Portland, Maine

NOTICE OF INTENT TO PROSECUTE

An inspection of the property located at 159 State St on 04/21/2015 revealed that the structure and premises fail to comply with NFPA 2009 Fire Code and/or NFPA Life Safety Codes. Attached is a list of those violations.

Owner/Manager STATE STREET CONGREGATIONAL CHURC		Inspector Craig Messinger	Inspection Date 4/21/2015
Location 159 STATE ST	CBL 045 A026001	Status Failed	Inspection Type Building-Fire - Change of Use Ins

First Floor Plan
State Street Church
 Portland, Maine

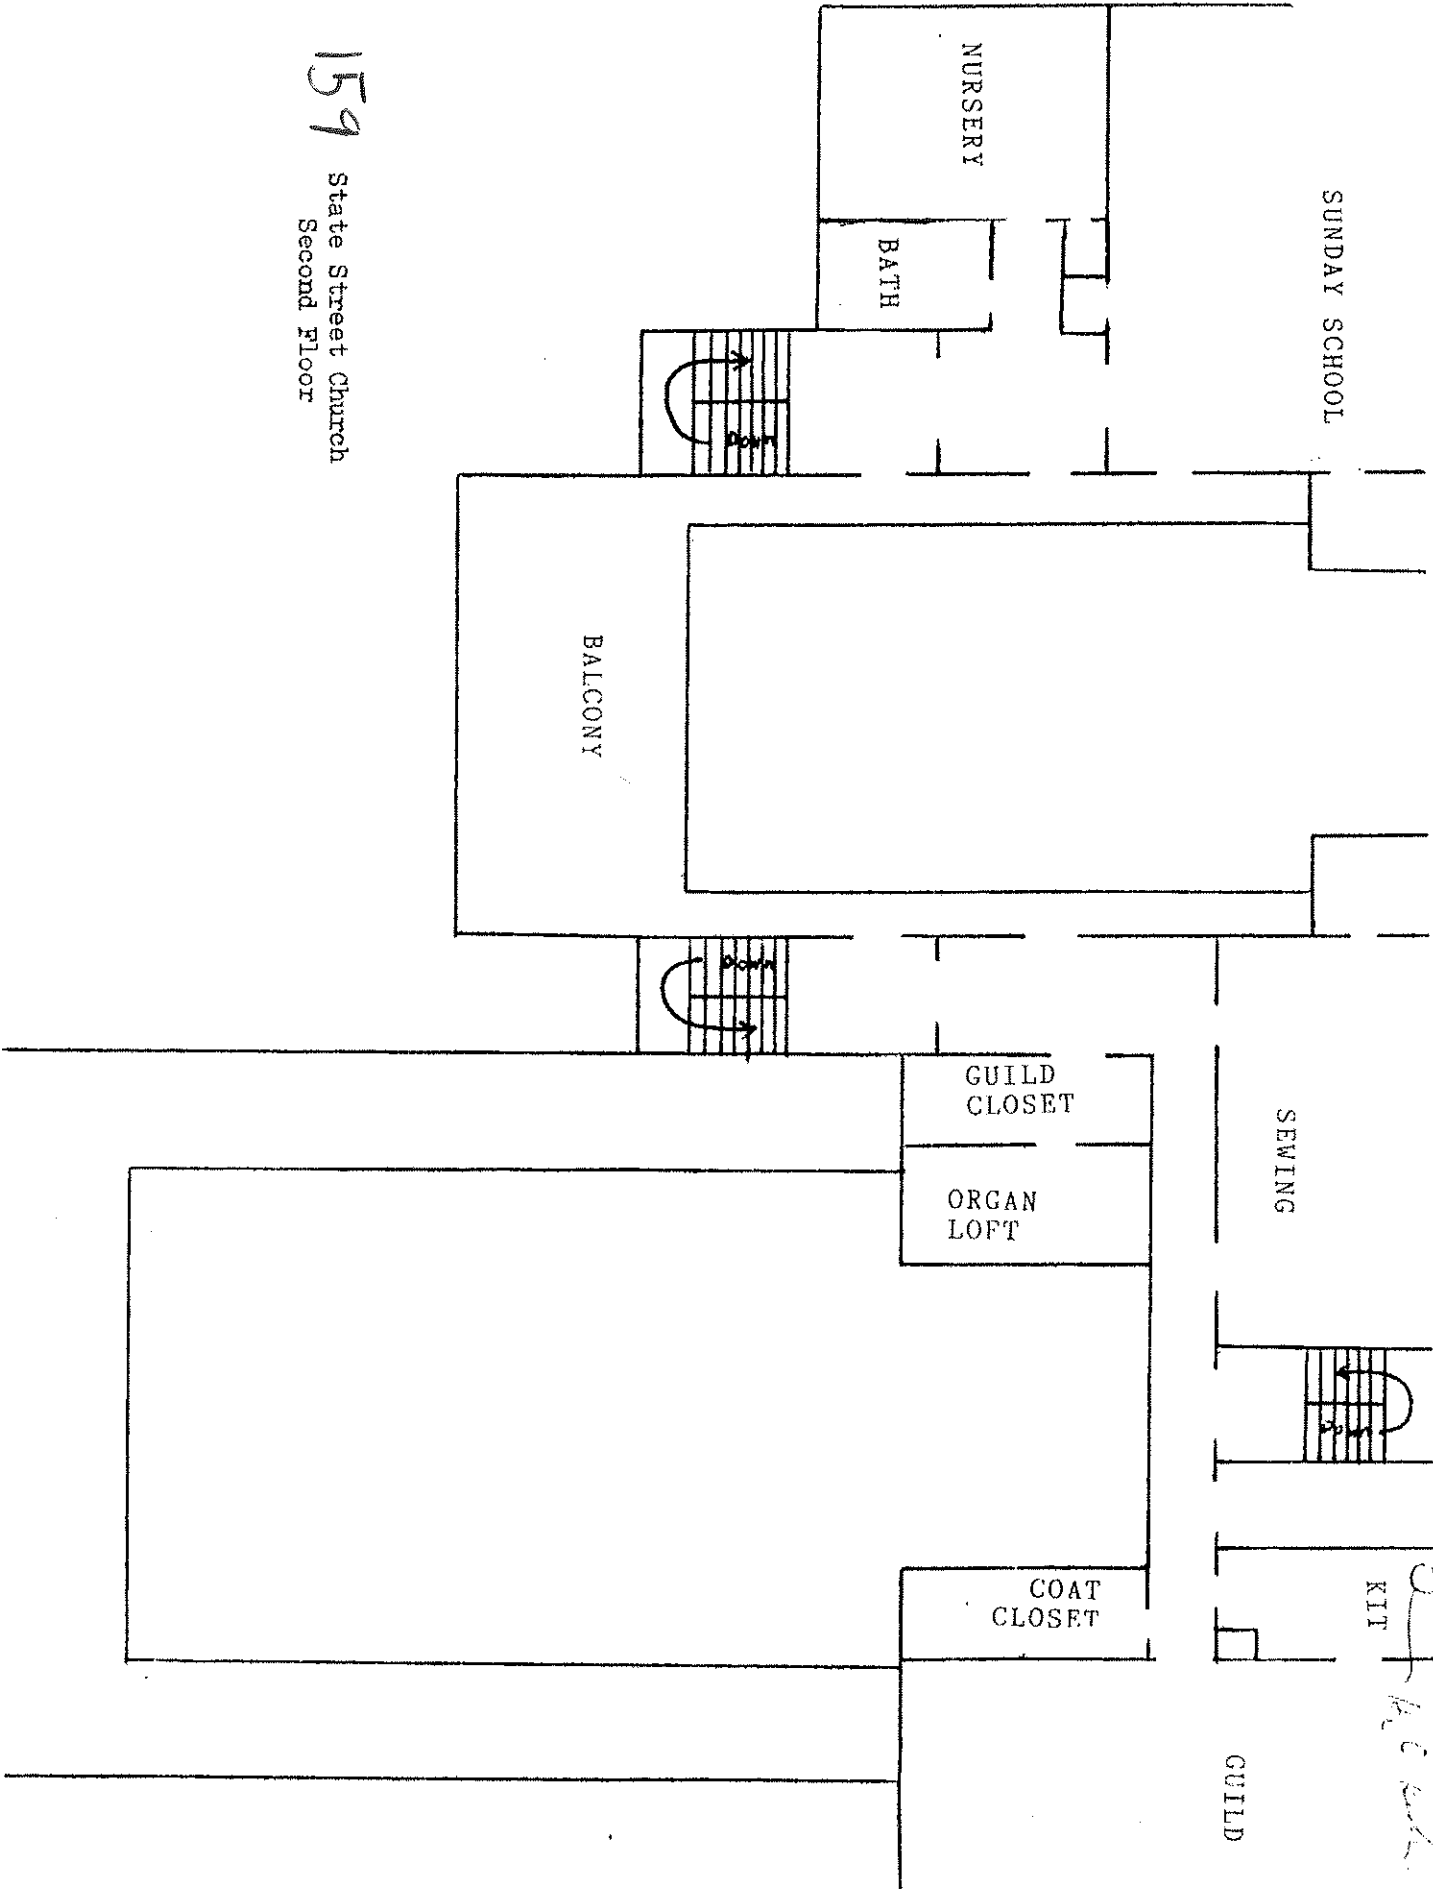
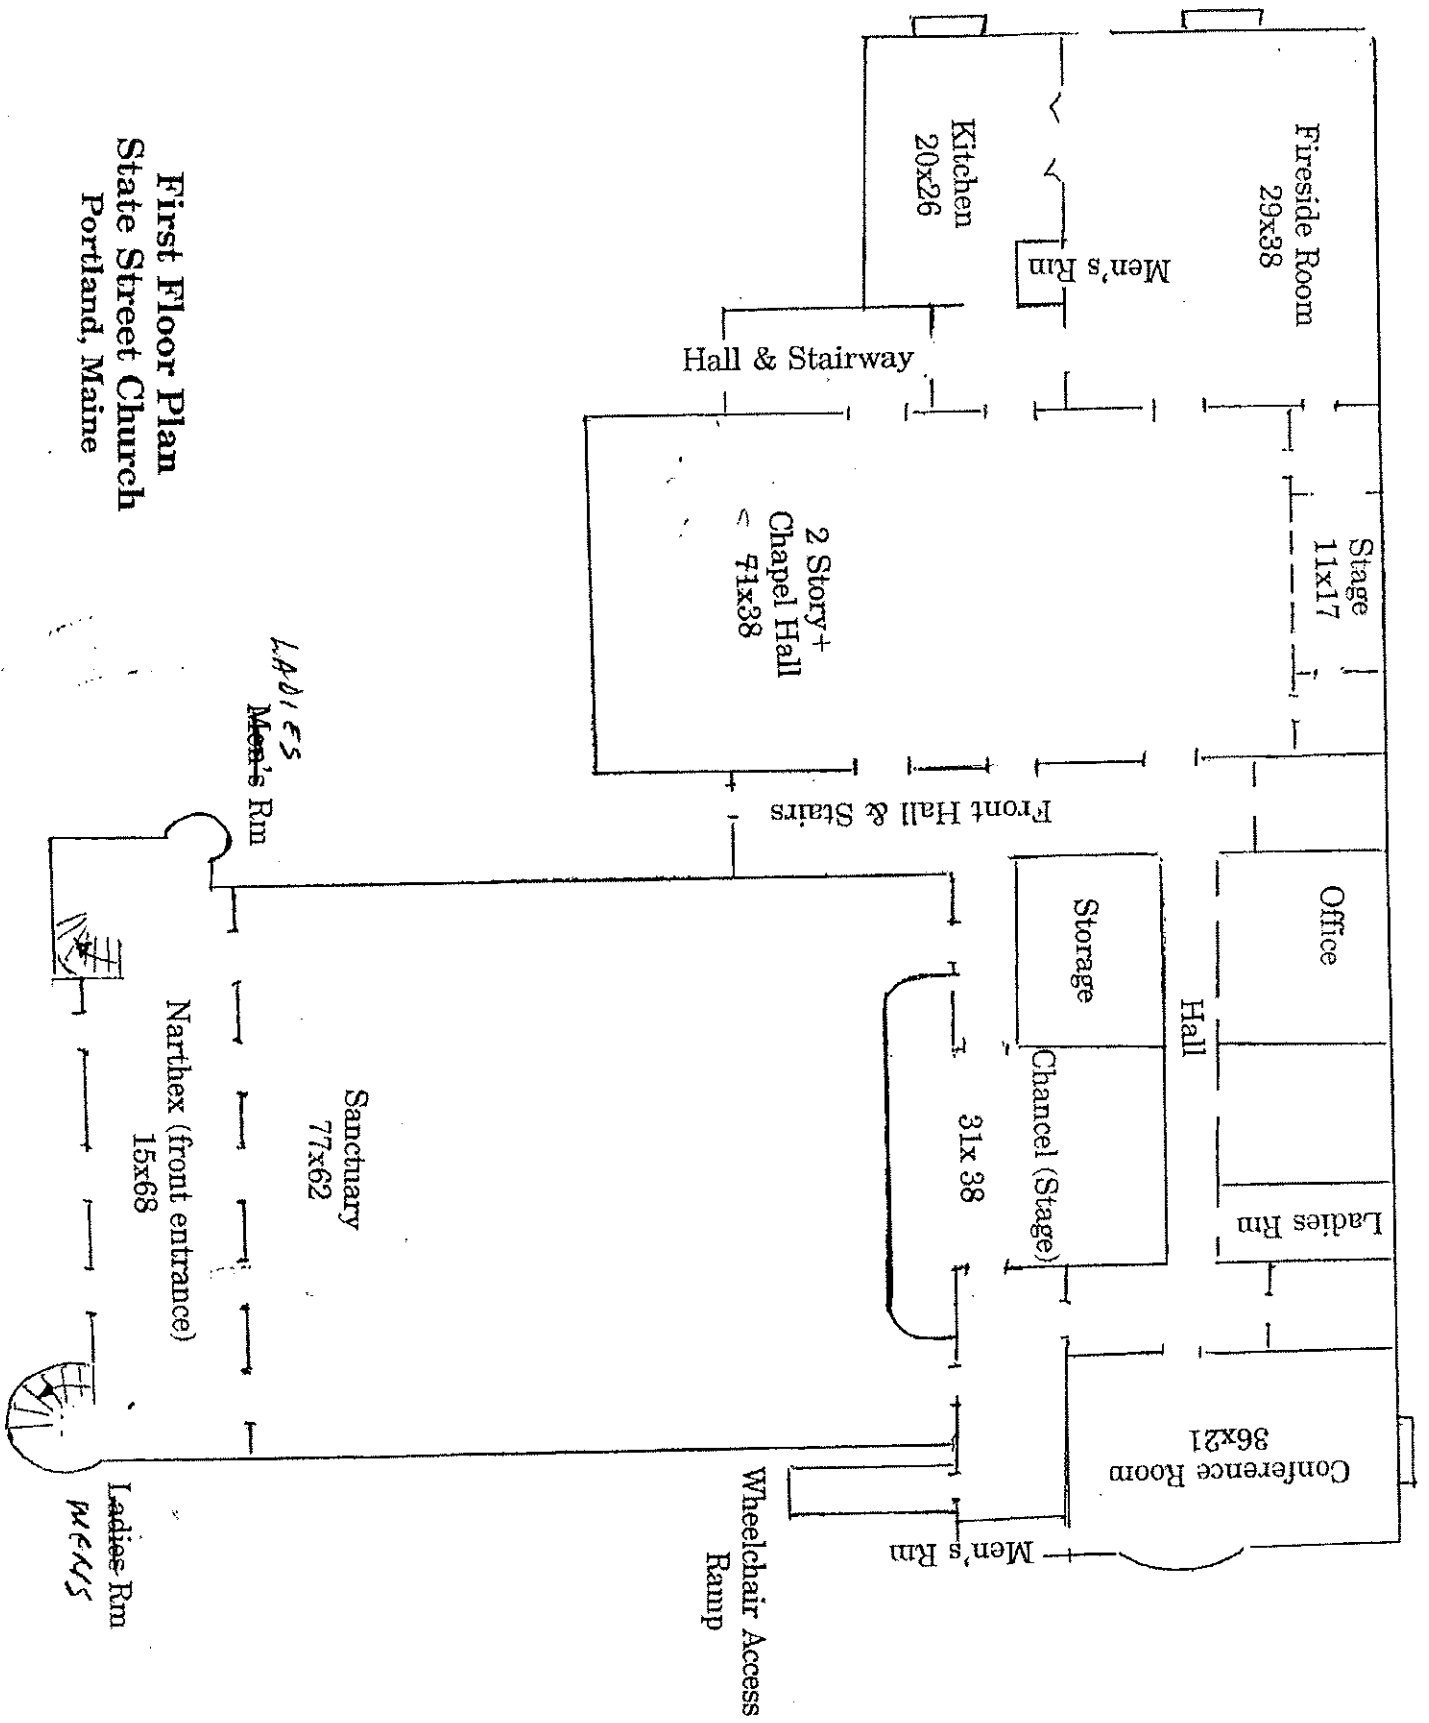
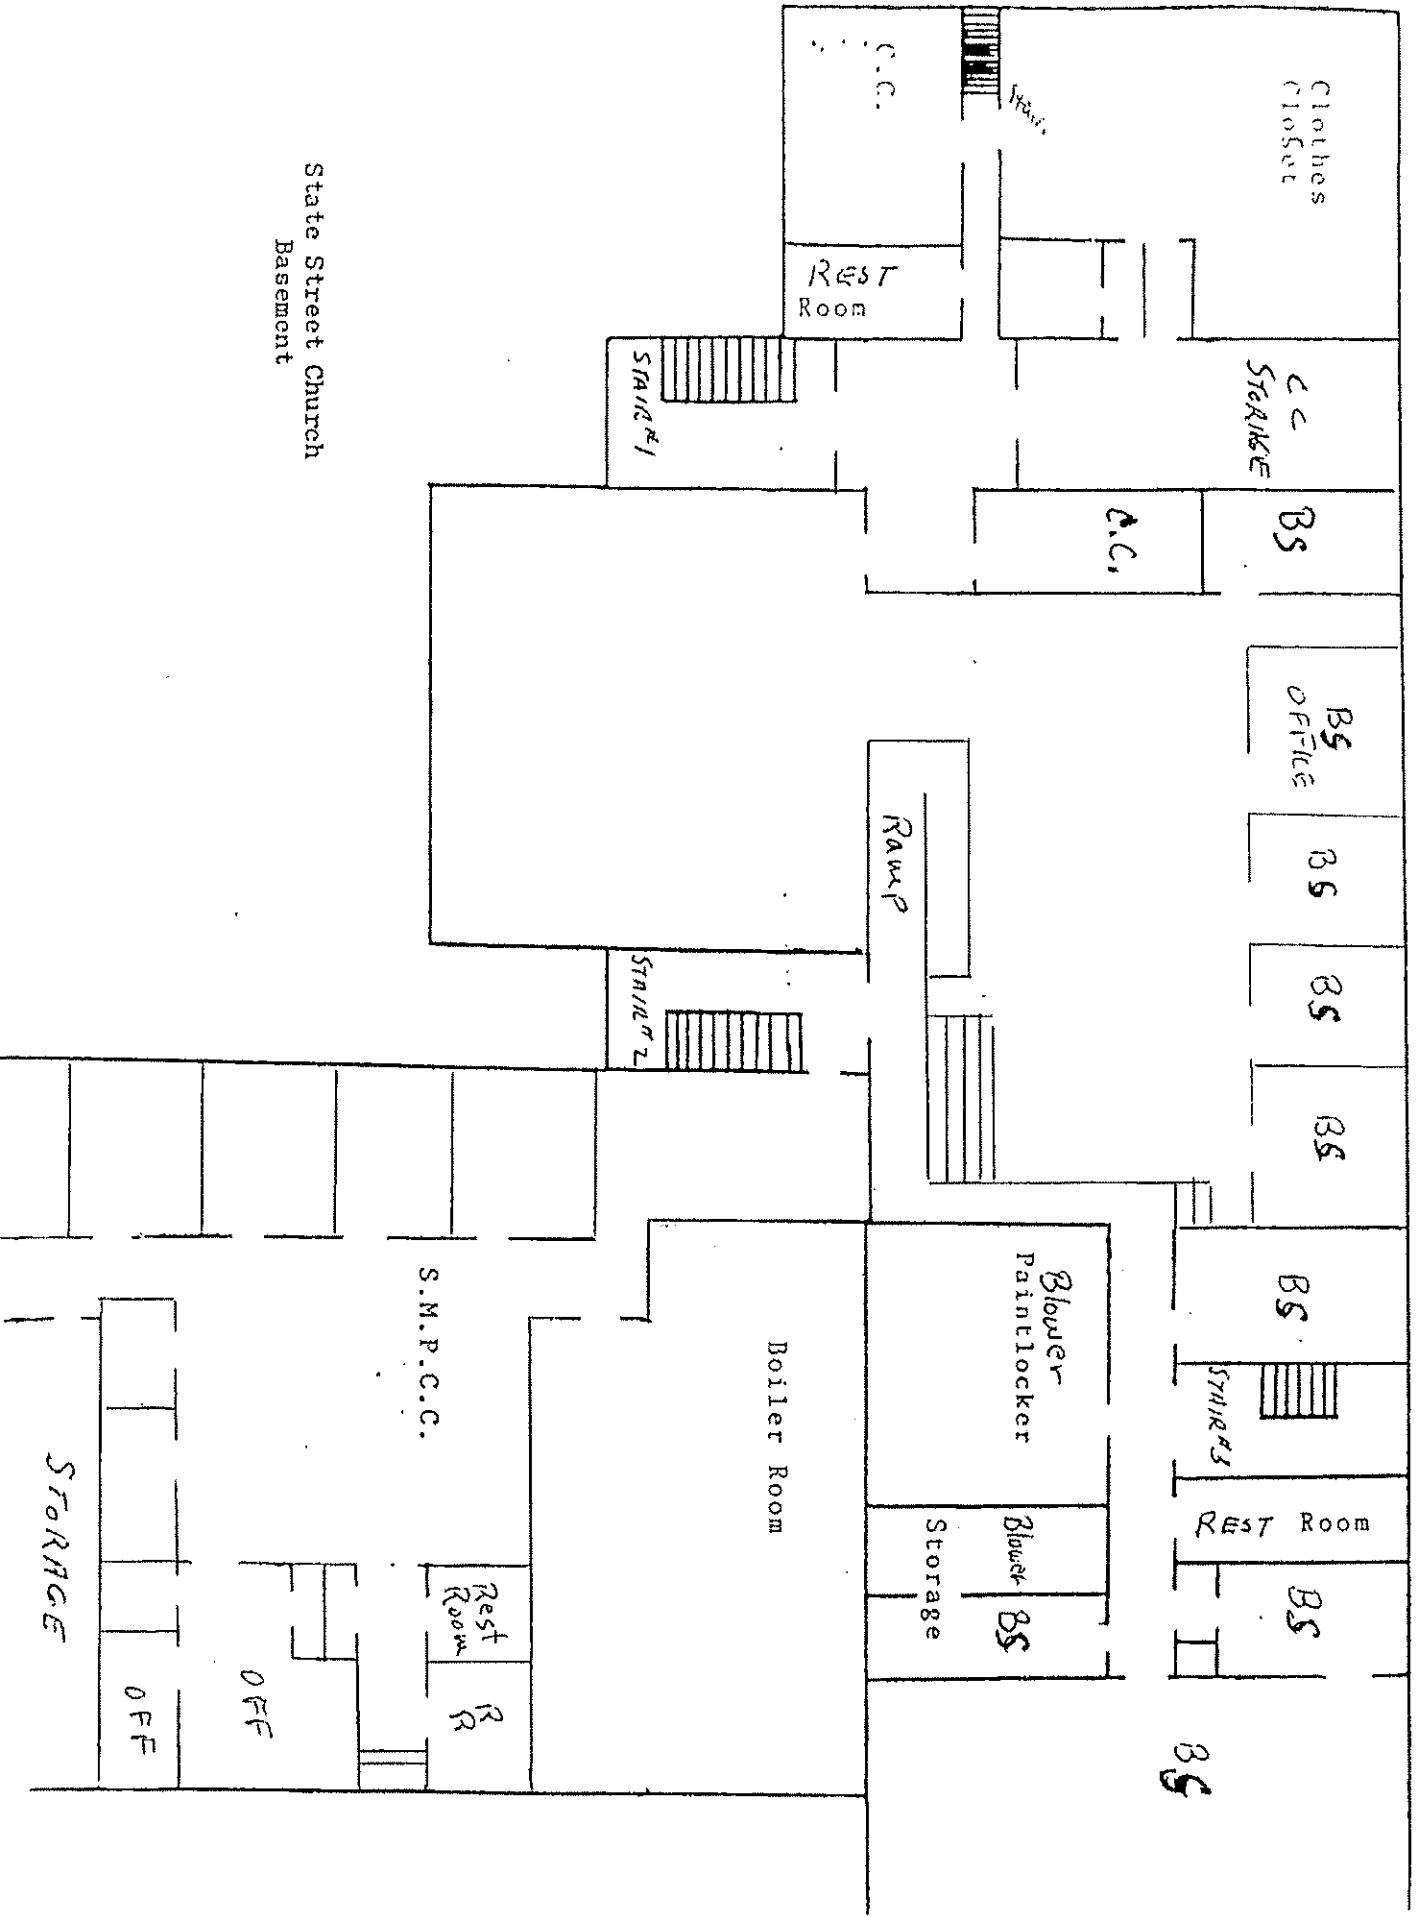
Violation: NFPA 101-40.2.4 MEANS OF EGRESS; THE NUMBER OF MEANS OF EGRESS SHALL COMPLY WITH EITHER 40.2.4.1.1 OR 40.2.3.2.

Notes: Second Means of egress required.
